From: [REDACTED]@winchester.gov.uk
To: [Aquind Interconnector](#)
Subject: Aquind Interconnector: Secretary of State Consultation on further information.
Date: 12 August 2021 16:59:36
Attachments: [Secretary of State response letter August21.pdf](#)

Planning Act 2008 and The Infrastructure Planning (Examination Procedure) Rules 2010 Application by AQUIND Limited for an Order granting Development Consent for the proposed AQUIND Interconnector (“the AQUIND Interconnector project”)

Secretary of State Consultation

The micro-siting of the converter station at Lovedean

TITLE: **Application document reference 2.7
Indicative Converter Station Area Layout Plans
Option B(i)
Sheet 2 of 3**

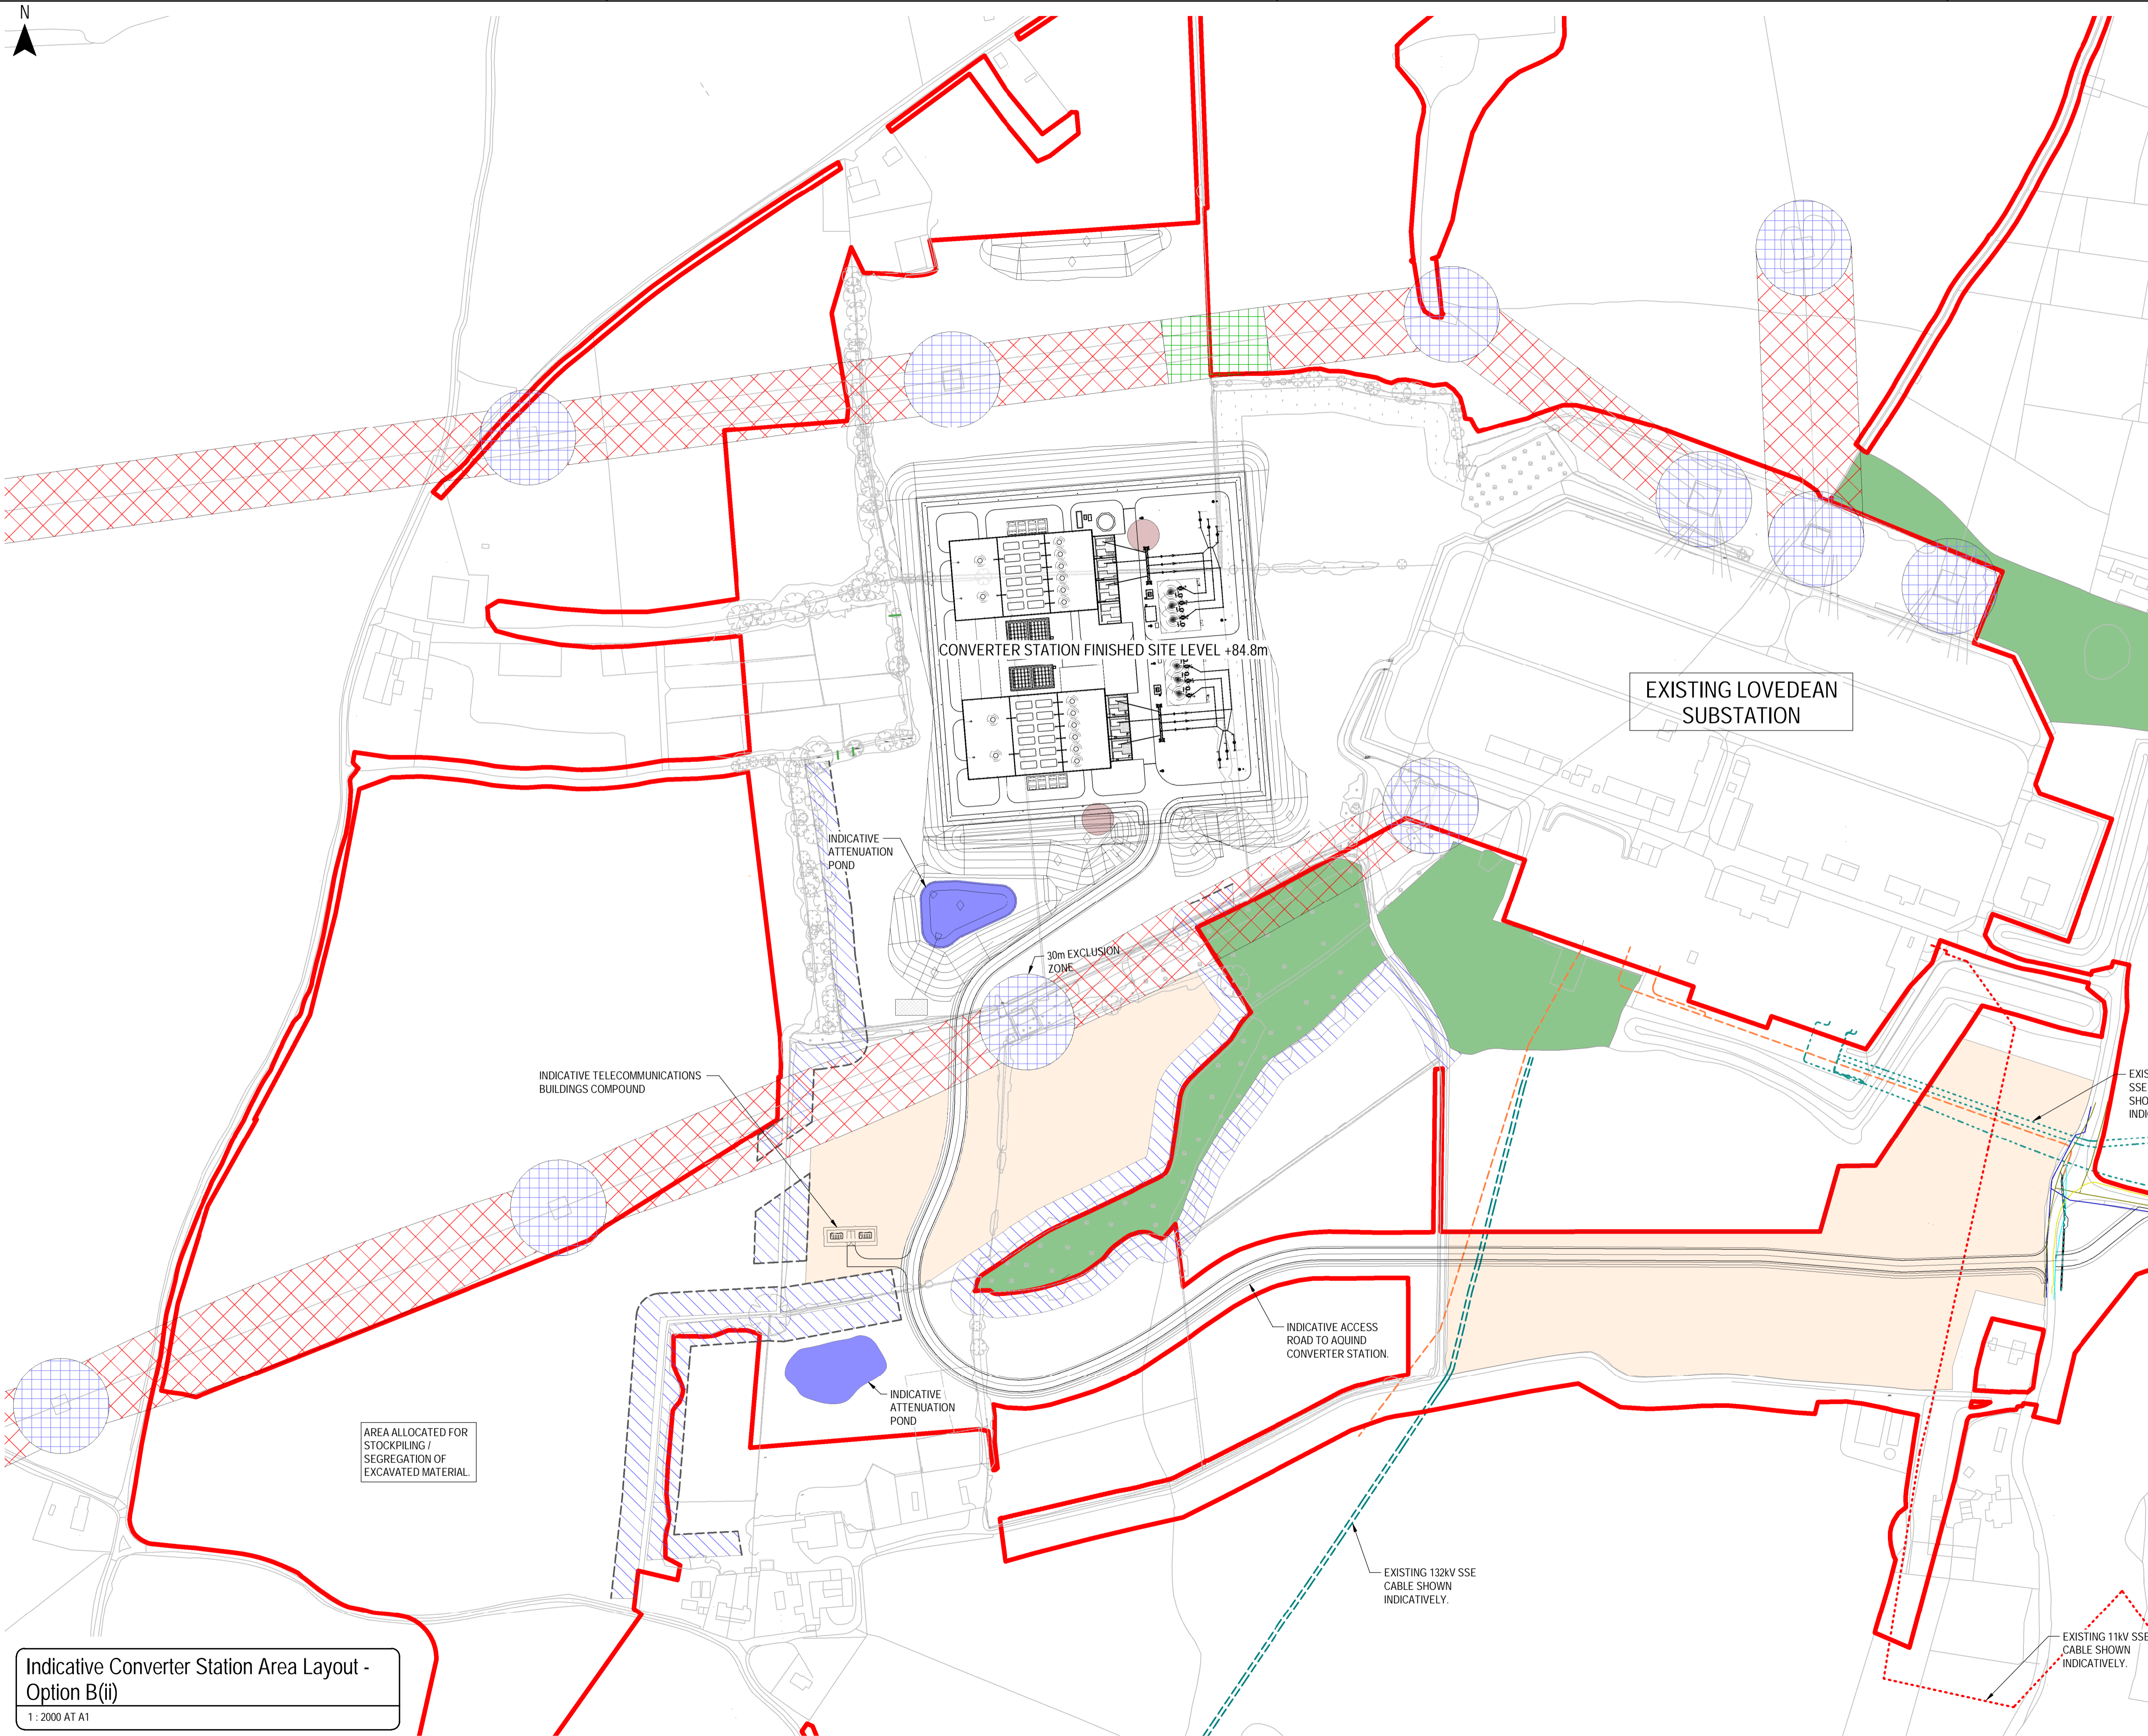
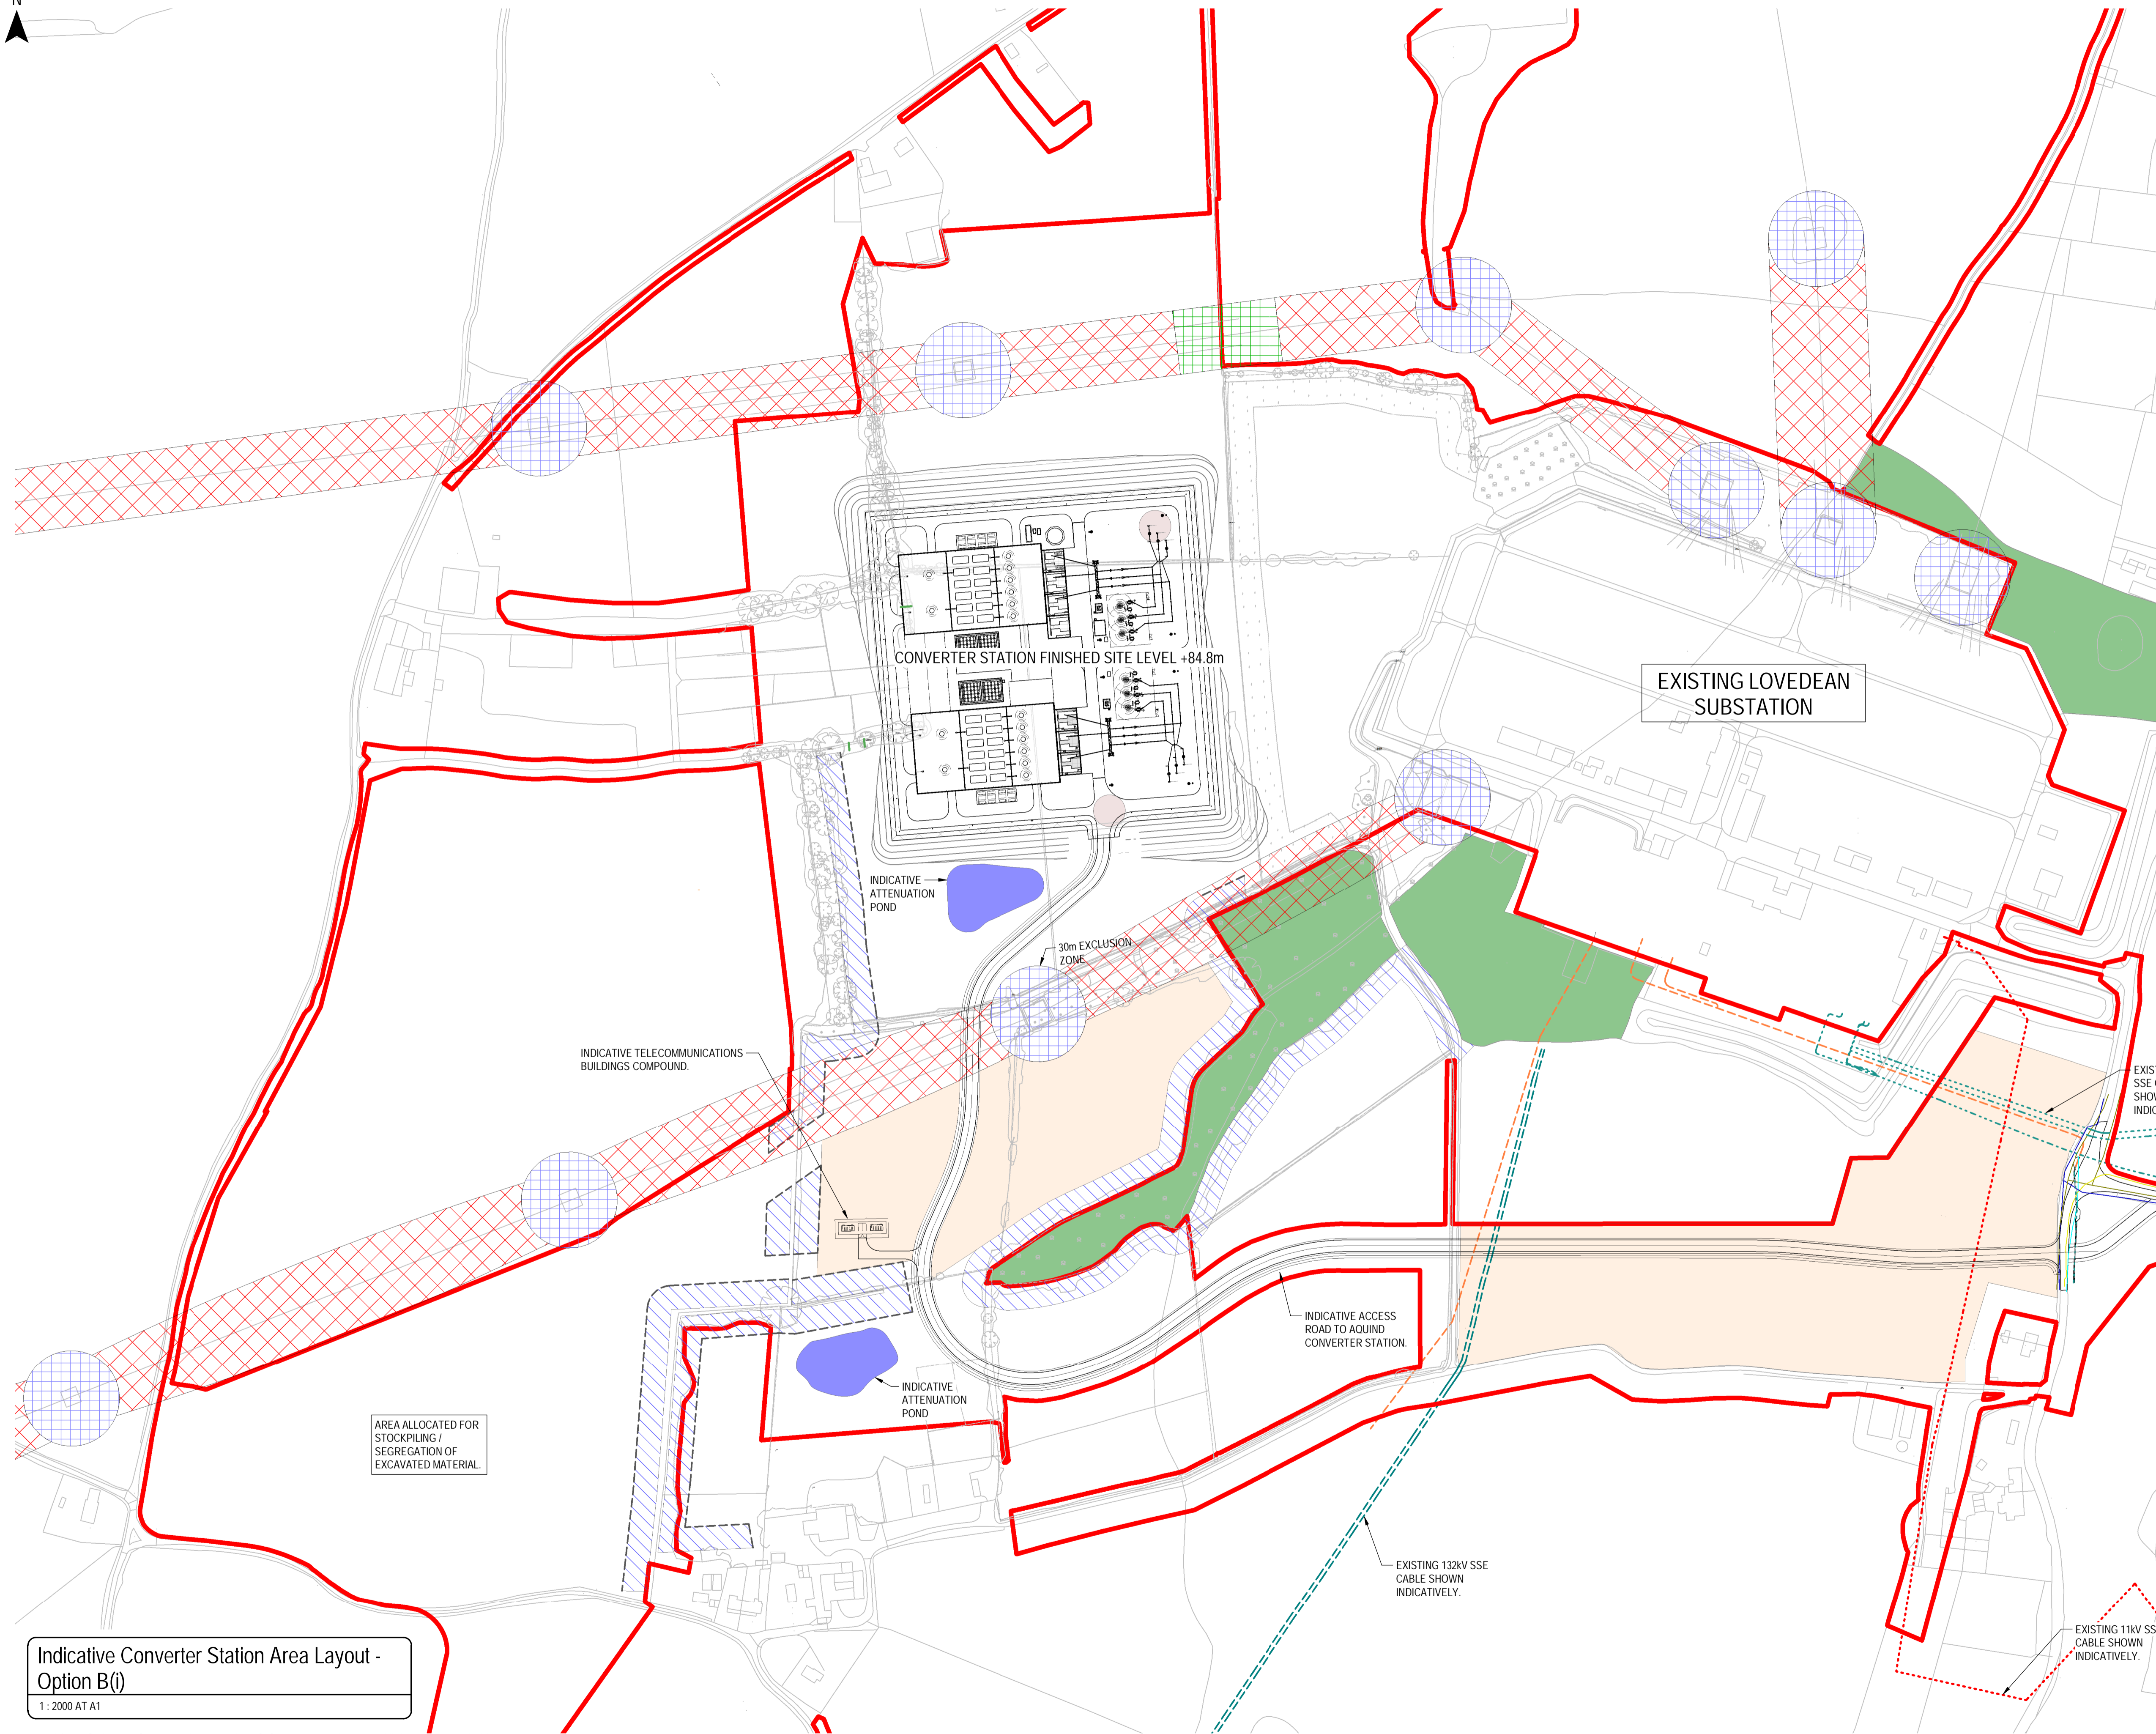
The application is putting two options forward for the position of the converter station relative to the existing substation. These are known as options B(i) and B(ii). The difference between them means that an existing hedgerow may or may not be retained. WCC would be severely concerned if the option B(i) was chosen that resulted in the loss of the hedgerow.

converter station compound to be considered. These are referred to as micro siting options B(i) and B(ii). Option B(i) would result in the loss of the north-south hedgerow. Option B(ii) would see the compound moved some 35m to the east that would allow the hedgerow to be retained. They are shown on the Indicative Converter Station Area Layout Plans sheets 2 & 3 respectively (APP-013). The applicant has presented the worst case option in the submission of (Bi). The final decision rests on the successful negotiations with the National Grid and whether they are willing to allow the release of the space needed to move the compound over.

If option B(i) is approved and construction, it would have a number of negative consequences from both a landscape and biodiversity aspect. The following hedgerows would be affected:

- The lower half of hedgerow HR05

- All of HR08
- The eastern part of HR06

This adds up to approximately 410m of species rich hedgerow and 25m of hedgerow will be lost (16.6.1.13). This includes some mature trees. This will also result in the loss of its biodiversity value including the loss of habitat for bats (section 16.6.1.27). It has also been recognised that two badger setts will also be destroyed (section 16.6.1.21). This action would weaken the landscape screen on the western side of the development removing the existing mature screen. This will be replaced by new planting as shown on Figure 6.10.1 Outline Landscape and Biodiversity Strategy Management Plan (APP-506). The new planting will obviously take time to mature into a condition that would provide the equivalent screening value and ecological value that the existing feature does.

The Council favours option (B(ii) as having the least impacts on natural features and habitat. Given the magnitude of the impacts associated with the implementation of option B(i) the Council would have severe concerns based on the landscape and biodiversity impacts as set out above. It is hoped the negotiations with the Grid can be successfully concluded.
